# PEDESTRIAN WIND ENVIRONMENT ASSESSMENT— RESPONSE TO SUBMISSIONS

16 November 2018

CPP Project 8839

Project: The Star, Sydney (Modification 13)

Figure 9: Proposed landscaping along Pirrama Road

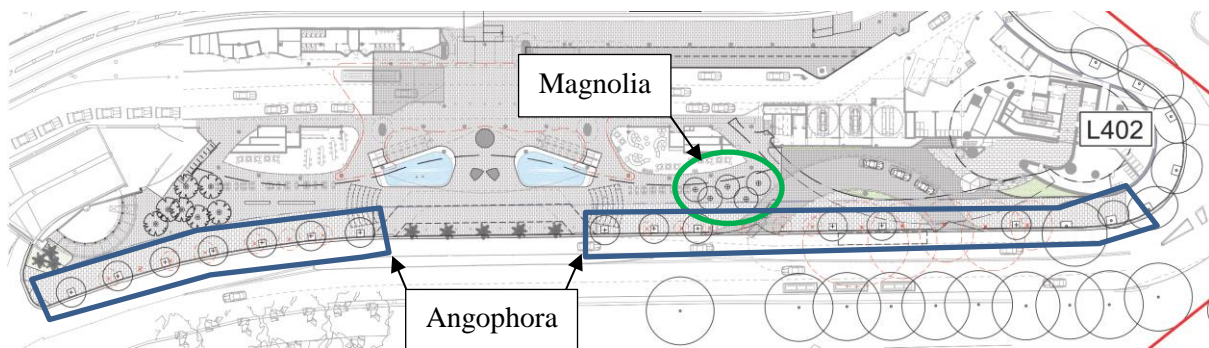
d) In the exhibited scheme, landscaping was proposed within the vicinity of the area at Location 14 on Pirrama road adjacent to the Lyric theatre office. This landscaping in combination with local vertical screening to the north-east of the seating area during windy days is expected to improve the wind environment from 'pedestrian standing' to 'pedestrian sitting'. Details of the proposed landscaping will be provided in the revised landscape packaging that will accompany the response to submissions report.

Figure 10: Pedestrian wind speed measurements on ground plane, existing configuration

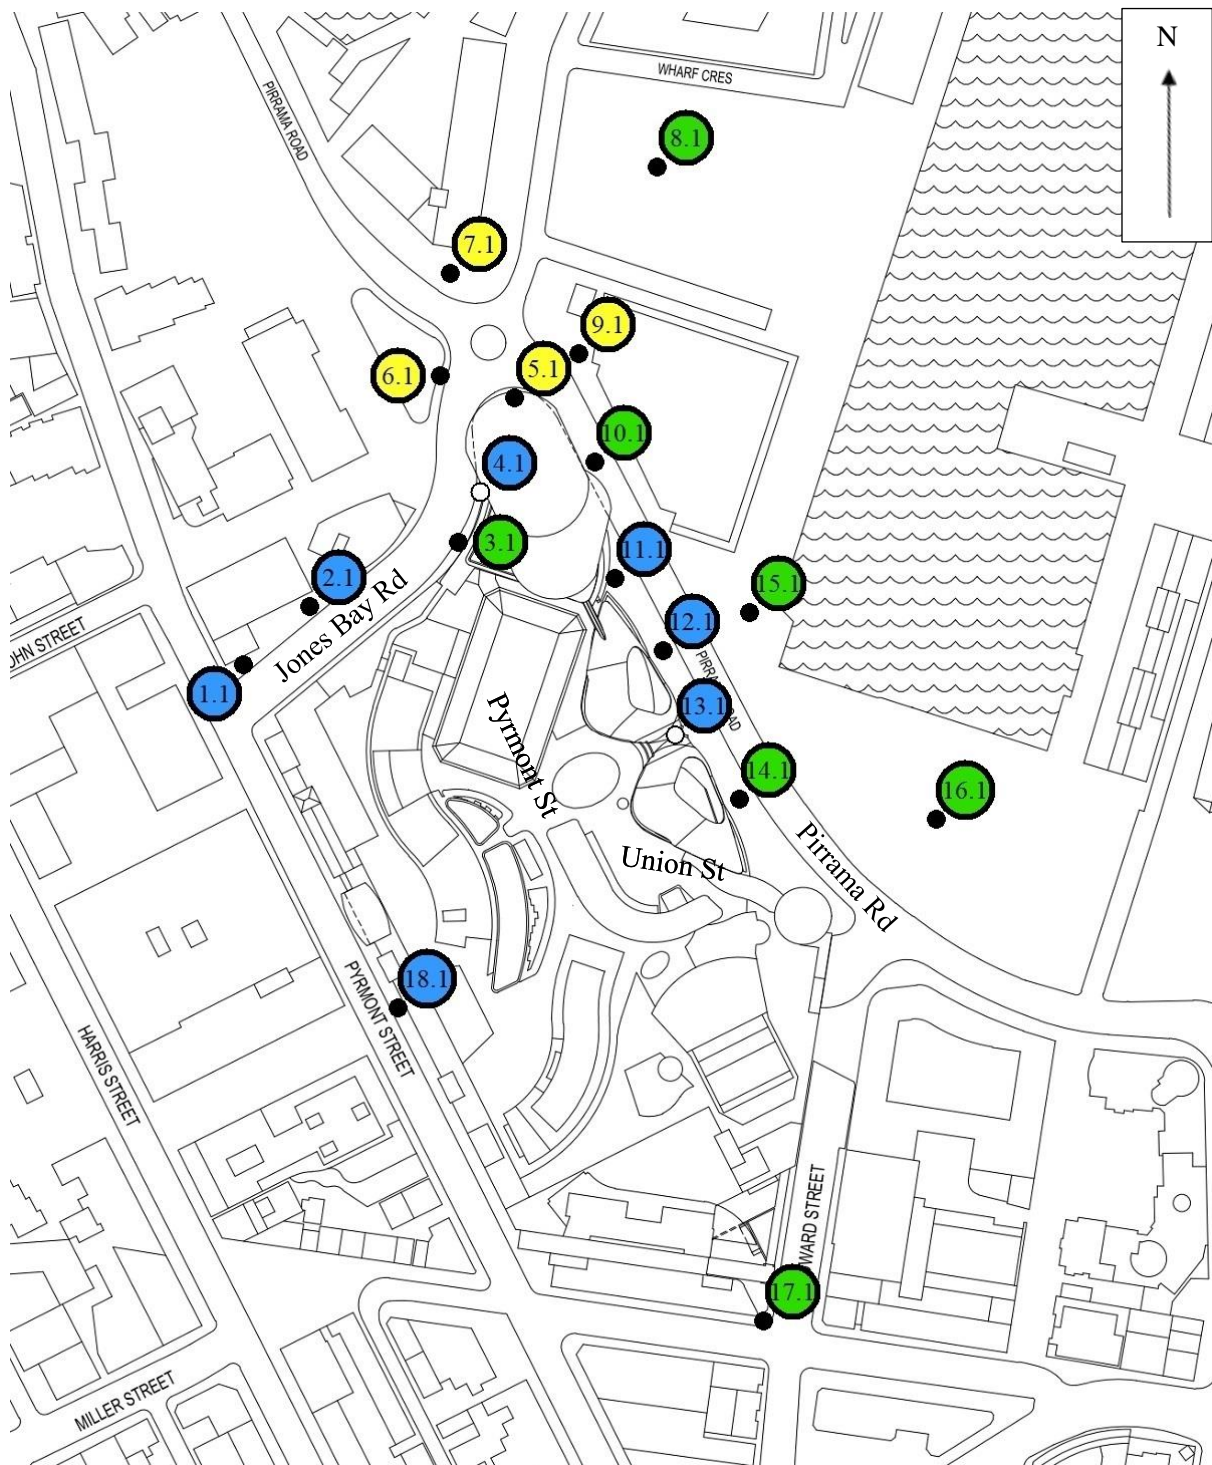
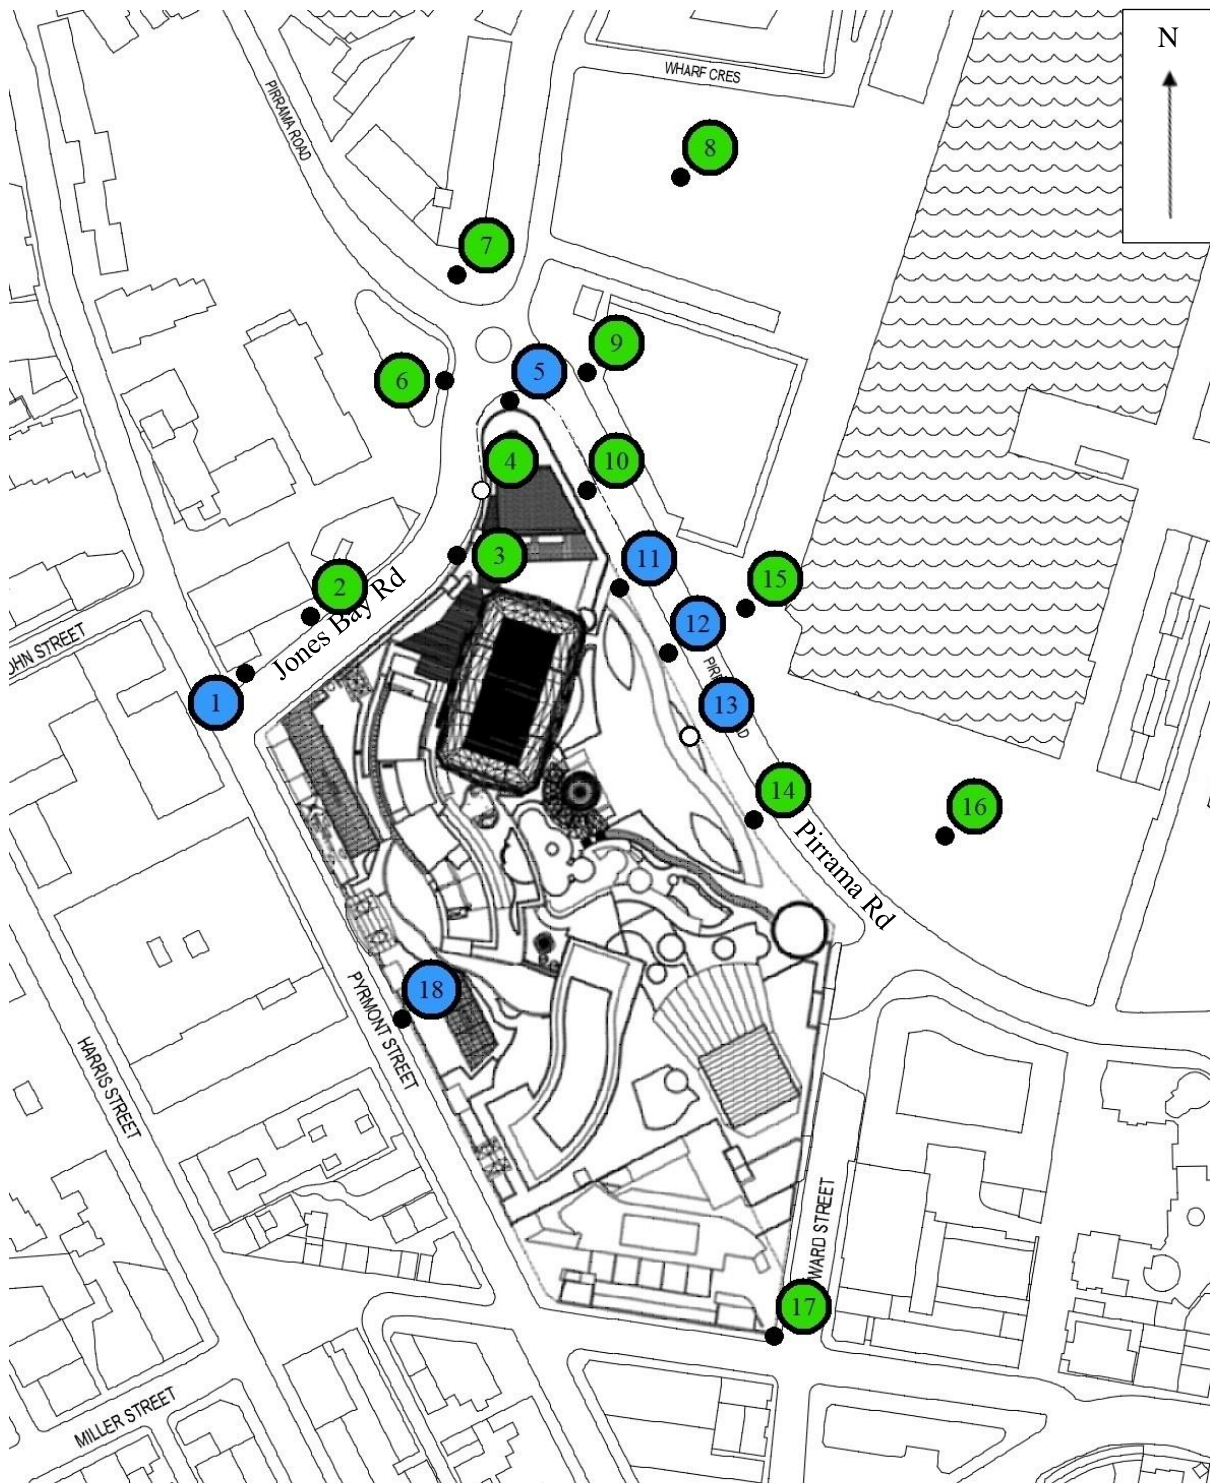
- a) *to allow for a comparison between the existing and proposed wind environments, confirm the 'as-existing' measurements for points 1 to 12*
- b) *assess the impact of the development at the following additional points:*
  - i) *the pedestrian outdoor seating on Jones Bay Road*
  - ii) *the entrance to 10 Jones Bay Road*
  - iii) *Pyrmont Bay foreshore, opposite the Pirrama Road entrance/frontage*
  - iv) *Pyrmont Bay Park and Metcalf Park.*
- c) *confirm whether the proposed mitigation measures at Level 59 Club Lounge Sky Terrace adequately address wind impact so that this space is functional for its intended purpose and does not pose a safety risk.*
- d) *consider providing additional wind mitigation measures to improve the wind environment comfort level at point 6 from 'pedestrian standing' to 'pedestrian sitting'.*

a) Multiple wind tunnel studies were conducted, including the test outlined in CPP report dated April 2018, to acquire ground level wind speeds surrounding both the existing site and the proposed Mod13 development site to allow comparisons of changes, if any, in the wind environment. The measurements are summarised in Table 1 and the measurement locations are presented in Figure 1 and Figure 2. Locations in close proximity of the tower experienced slightly windier conditions than in the existing configuration, however wind conditions remain suitable for the intended purposes of these areas. The remaining locations experienced similar wind conditions in both configurations.

b) Wind conditions at 10 Jones Bay Road (Location 6) were slightly windier with the addition of the Mod13 exhibited scheme and tower, however this level of wind is still suitable for the intended purposes of this area as a space for moving pedestrians.

Wind conditions within the pedestrian outdoor seating on Jones Bay Road (Location 3), Pyrmont Bay foreshore (Location 15), Pyrmont Bay Park (Location 16) and Metcalf Park (Location 8) experienced similar wind conditions in both existing and proposed configurations, and thus the Mod13 exhibited scheme had limited impacts on the wind environment in these areas.

Figure 15: Pedestrian wind speed measurements in the Club Lounge Sky Terrace on Level 59

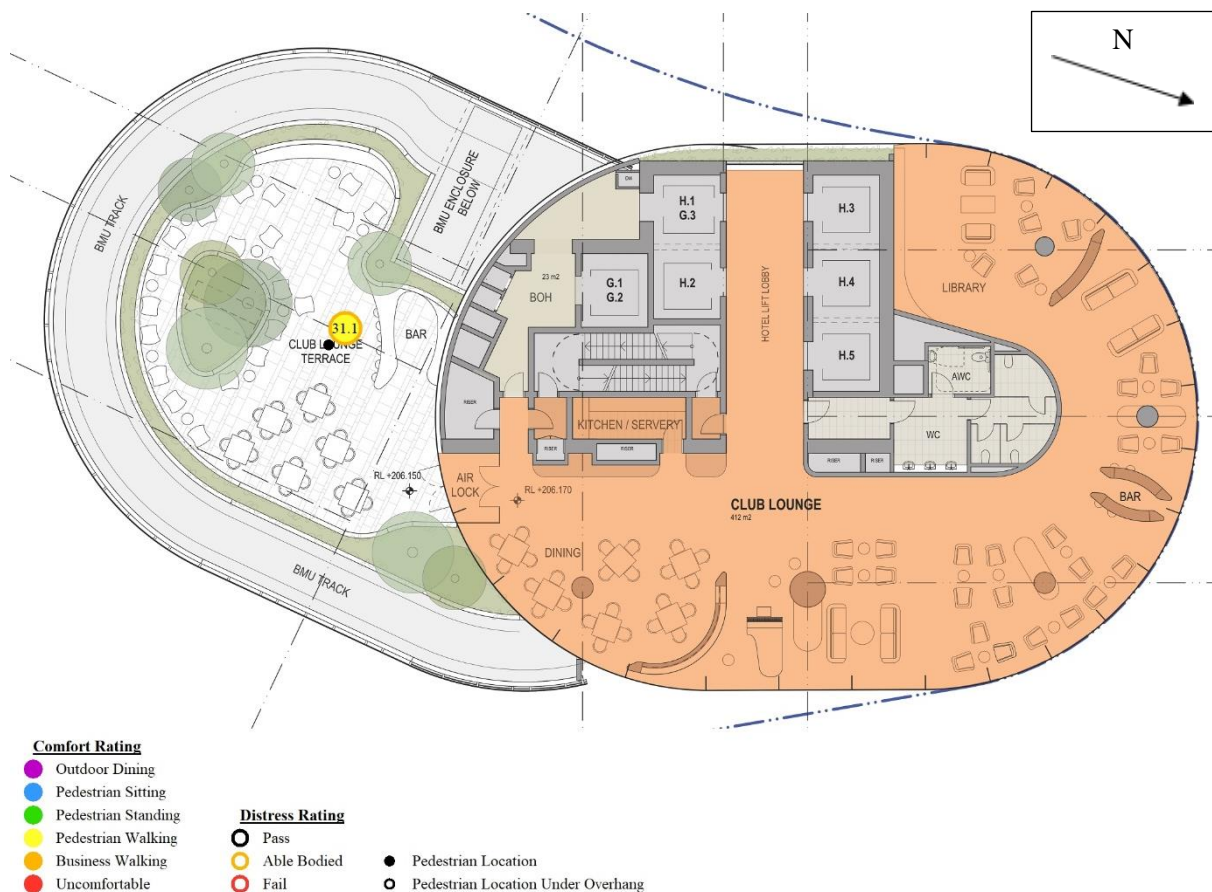
*The Level 59 Club Lounge description does not match the plans. There is no wind study evidence to confirm that the landscaping proposed has been designed to withstand the western aspect and likely wind effects. Is the proposal achievable at upper levels of the tower?*

The wind tunnel model used in the study conducted April 2018 included a balustrade equivalent to 6 m in height at full-scale around the perimeter of the Level 59 Club Lounge Terrace, however tested without

proposed landscaping. Proposed local landscaping and vertical screening surrounding the seating areas, evident in the exhibited scheme landscaping plans, would help improve conditions to levels that will be suitable for its intended purposes and will pass the distress/safety criterion.
